From: Tim Townsend [REDACTED]
Sent: 15 January 2015 15:17
To: Darren Schofield
Cc: Neil Crowther
Subject: RE: Courtwick Littlehampton - Application Ref LU/253/14/DOC

Tim Townsend | Senior Planner, Planning Applications - Strategic Development, West Sussex County Council

ROAD SUB-GRADE

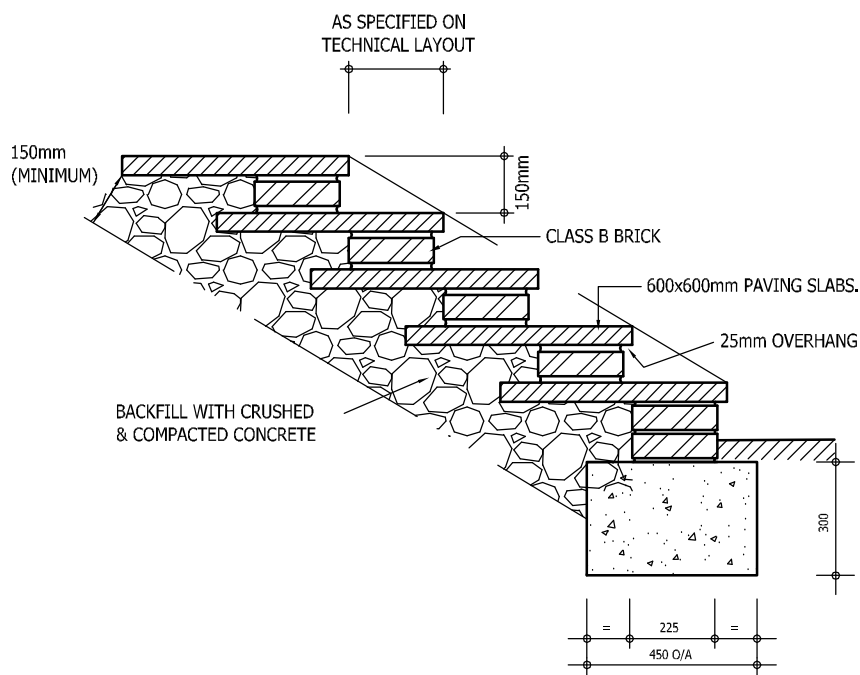
- i. *Swept-path diagrams* – still required.
- ii. *Street lighting* – Please confirm that a scheme of street lighting fit-for-purpose will be provided.
- iii. *Road construction specification* - Please confirm that all roads will be constructed fit-for-purpose.
